Application by Gloucestershire County Council for an Order Granting Development Consent for the M5 Junction 10 Improvements Scheme: TR010063

Submission made by the Joint Councils pursuant to Deadline 3 (D3) of the Examination of the M5 Junction 10 Improvements Scheme

Documents on Landscape Visualisations Viewpoints [REP2-003, REP2-004, REP2-005, REP2-006 and REP2-007]

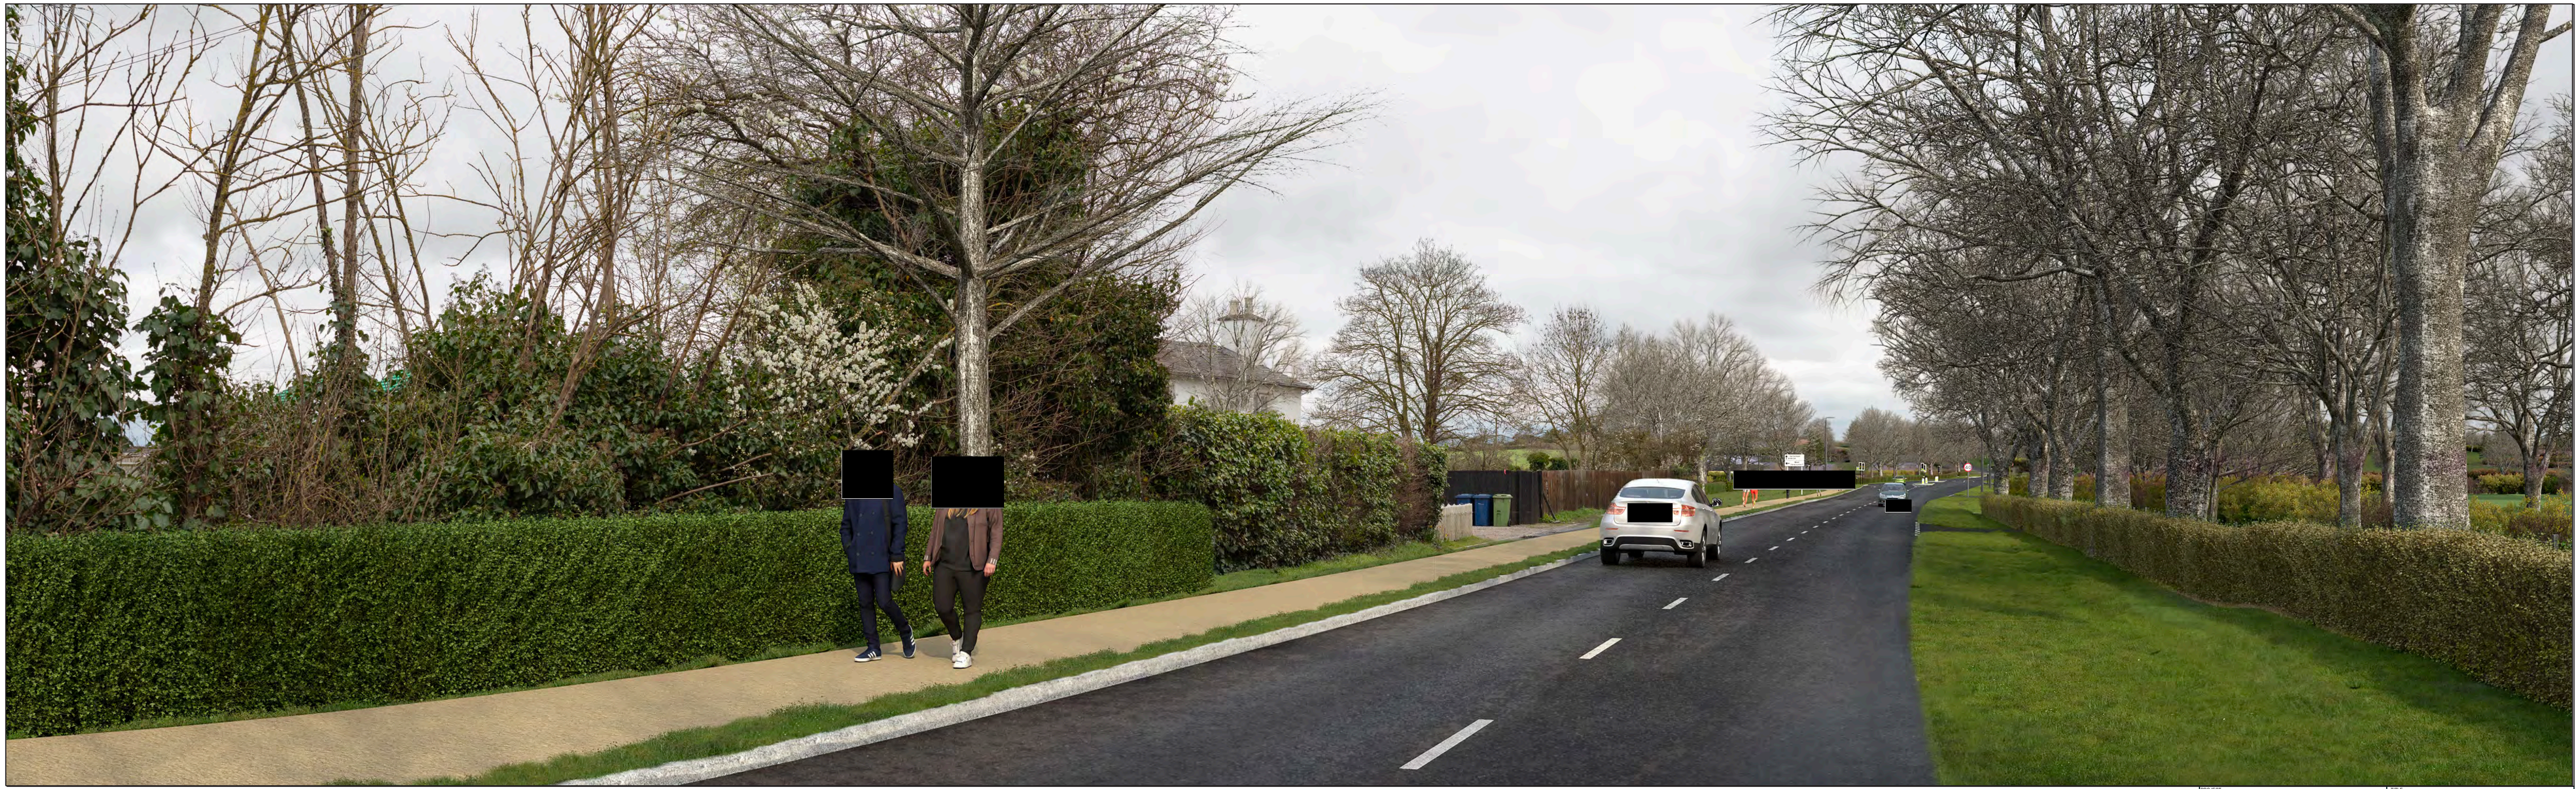
1. The visual representations of trees at year 15 appear significantly larger and more mature than one would expect, given that many are depicted as small saplings (under 1 meter) at the outset or as trees less than 2 meters tall. It raises the question of whether there is a documented methodology detailing how these year 15 tree sizes were determined, including annual growth rates, height spread, and trunk size. The projection of most trees reaching heights of 10 metres or more seems overly optimistic, especially for slow-growing species, and does not take into account the limited growth typically observed during the first 2-3 years post-planting. Growth rates are, of course, subject to variation based on environmental conditions, but the visuals seem to represent an ideal scenario. In reality, the trees may not achieve such robust growth. Therefore, it might be more prudent for the visuals to depict a more conservative growth scenario, such as the worst-case or even an average growth rate, to avoid giving a misleading impression. Additionally, it would be beneficial to provide explanations regarding the methodologies used to determine the sizes of trees and vegetation projected at year 15.

2. The acoustic fence is depicted as a standard timber structure in all visual representations. However, it is important to note that the final design has not been established. The Landscape and Visual Impact Assessment (LVIA) anticipates that all fencing will incorporate greening elements, such as climbing plants, to soften their appearance and lessen their visual impact. This discrepancy between the visuals and the assessment's description is concerning. Particularly, certain images suggest insufficient space for planting to be successful – for example, Viewpoint 06 shows a minimal gap between the kerb and the fence, which is likely to be filled with the concrete foundations necessary for the construction of both the fence and kerbs. To resolve this inconsistency, it is imperative that either the visuals are updated to reflect the greening measures outlined in the LVIA, or the assessment's evaluated impact is revised to align with the current visualisations. Without these changes, the visuals fail to accurately represent the mitigation strategies detailed in the LVIA documentation.

3. In the year 1 visuals, the depicted grass areas present a dense and verdant sward, which does not accurately reflect the expected reality. It is anticipated that the majority of these areas will be sown with diverse meadow mixtures that require several years to fully establish. Consequently, during the first year, it is more probable that one would observe considerable patches of bare soil interspersed with only sporadic green growth. The year one imagery, therefore, does not provide a true representation of the greening process for verges and embankments, potentially setting unrealistic expectations for early development.

5. The hedges depicted in the visuals do not seem to represent the native hedgerows proposed accurately. They are presented as being quite diminutive, even at 15 years of growth, which contradicts the expected development. Furthermore, the image suggests a uniform species, neatly trimmed hedge, which is a departure from the diverse and natural appearance suggested in the landscape proposals. The proposals likely envision a more robust and varied hedgerow that would typically include a mix of native plant species, contributing to local biodiversity and offering a more authentic representation of the natural landscape.
